TaylorThomsonWhitting

10th July 2012

CAMPBELLTOWN HOSPITAL STAGE 1 REDEVELOPMENT

Response to Submissions

SCALE 1: 200

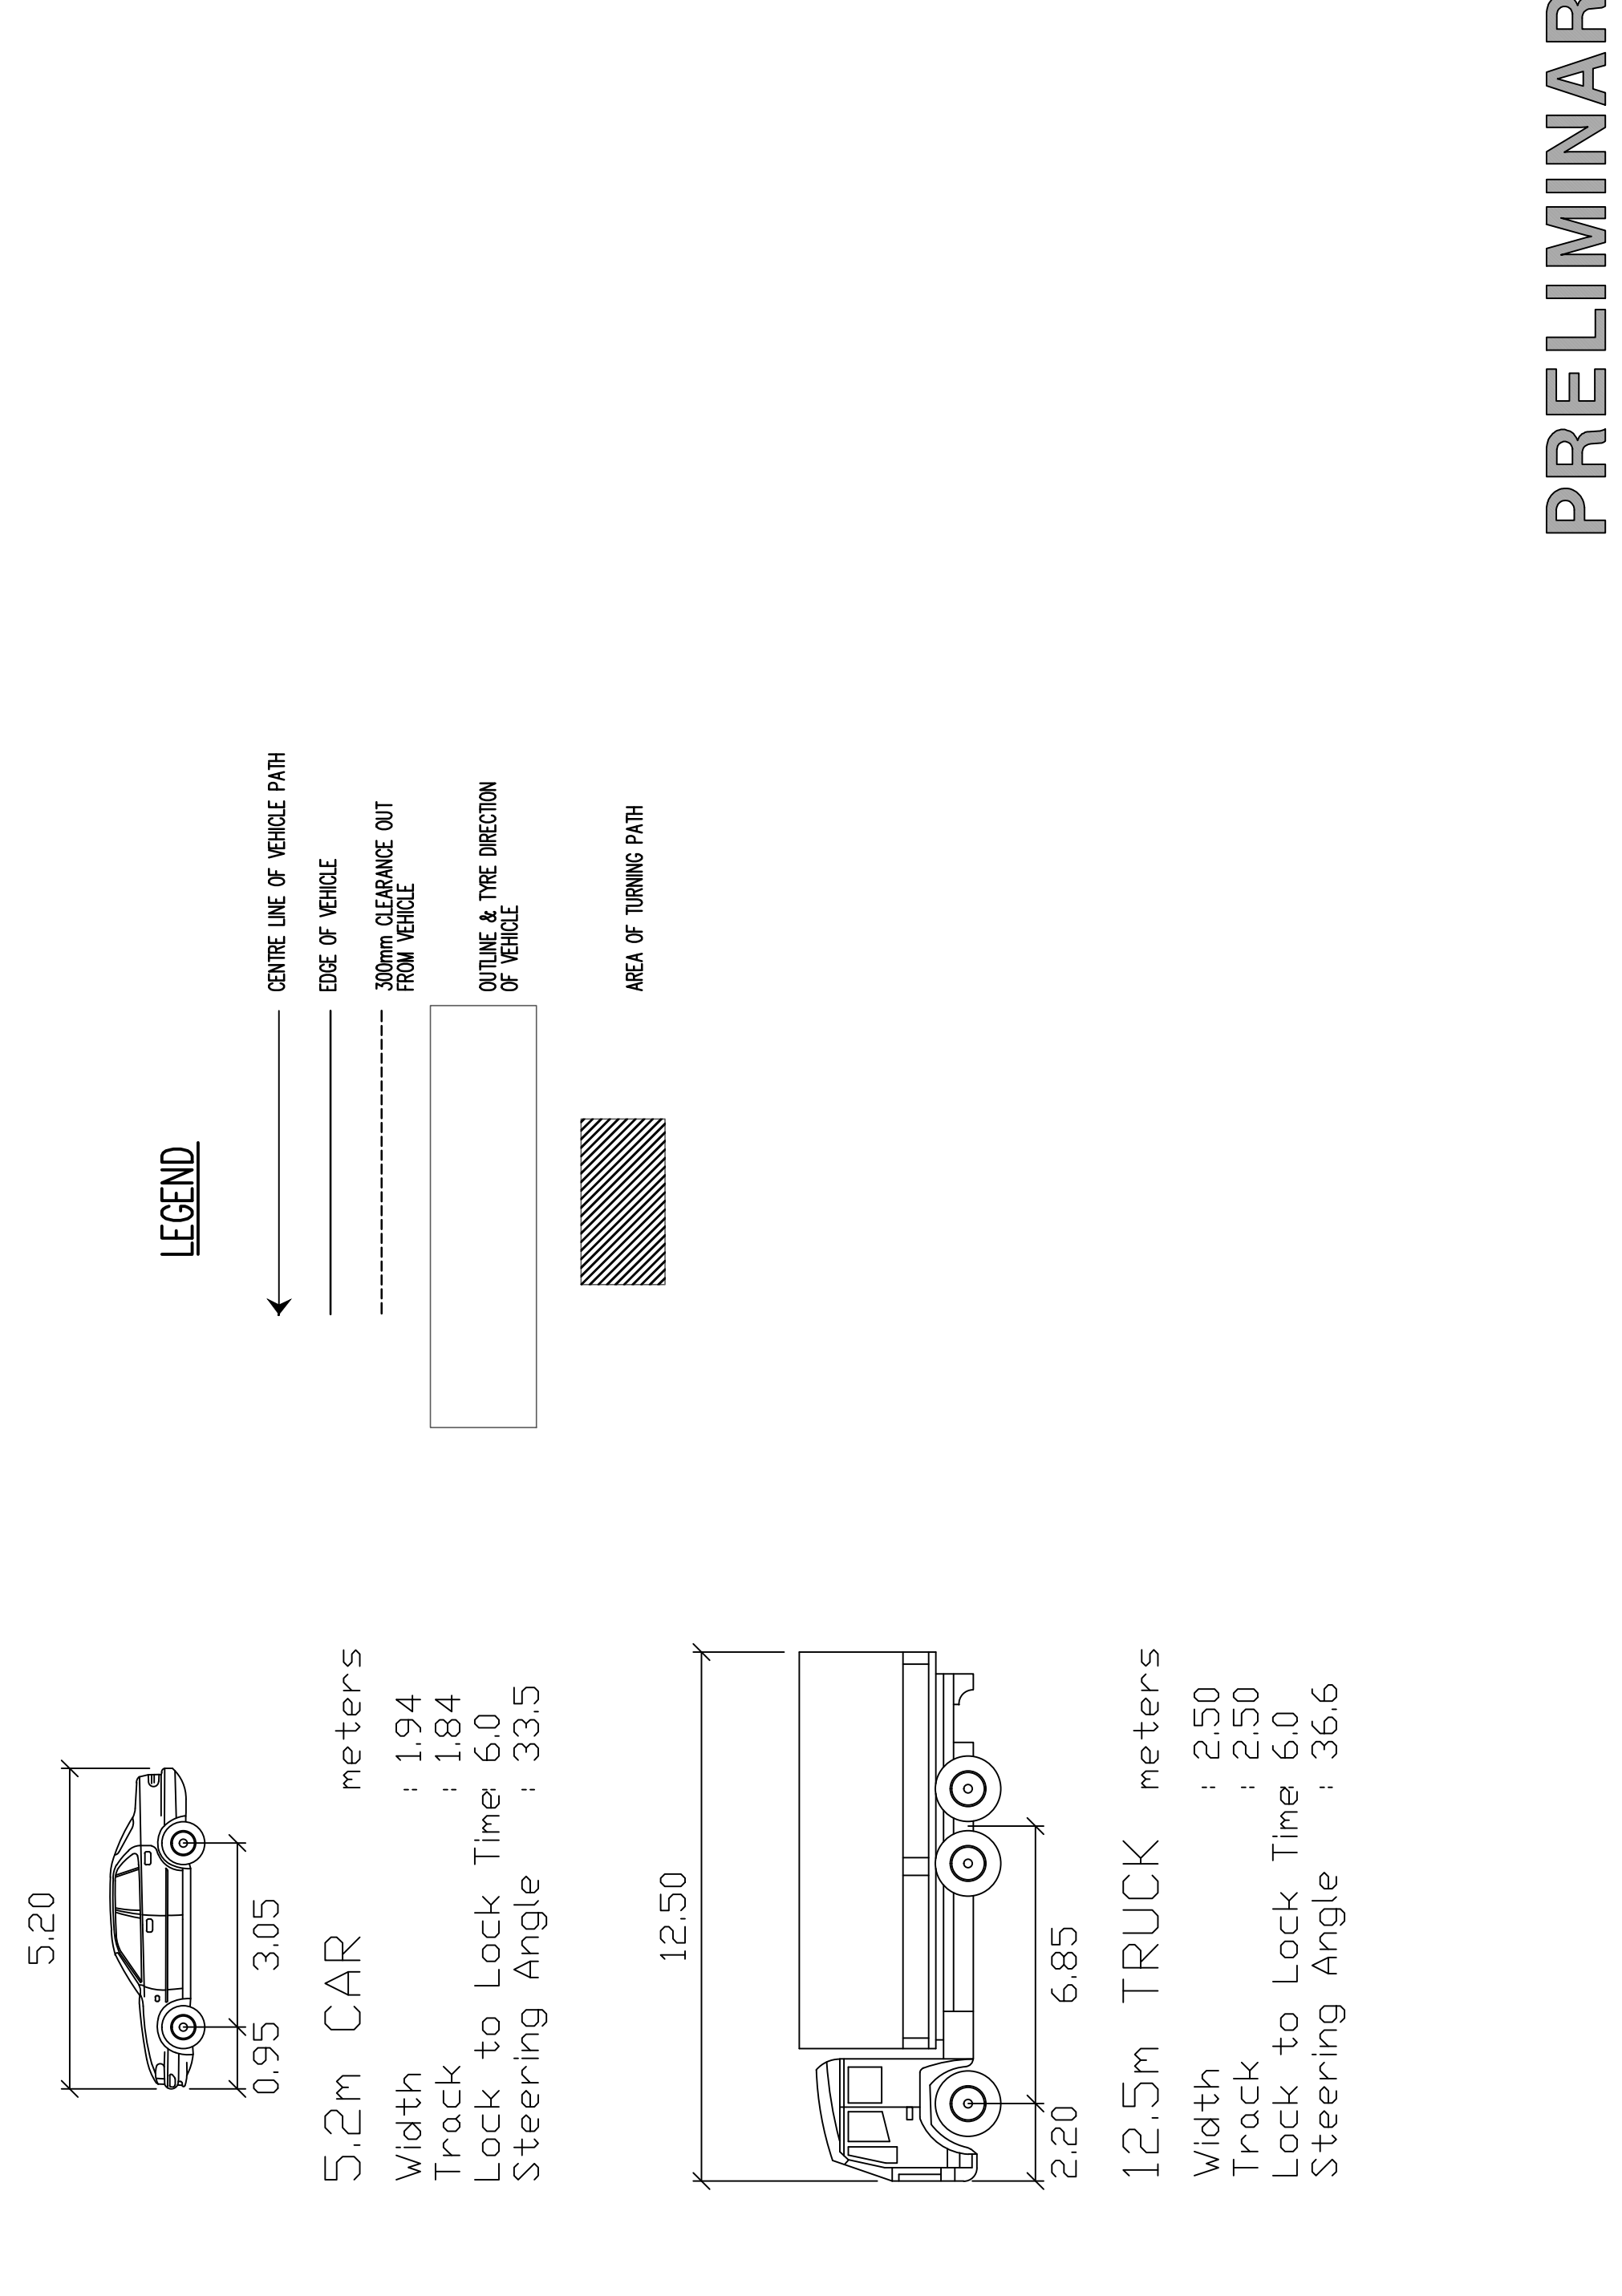
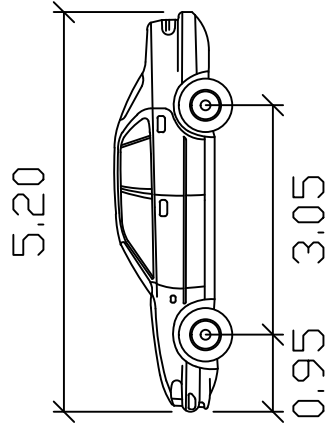
5) The traffic and parking report does not mention nor considers access for plant and maintenance.

Access analysis and turning paths have been carried out and included as part of the development application documents including loading areas. Section 4.2.2 of Traffic and Parking Report has also addressed the service vehicles access.

The use of new service access for plant room and maintenance to the site is limited (i.e. less than 10 vehicles per month) and appropriate turning paths and access arrangements are shown in Exhibition 1, attached document.
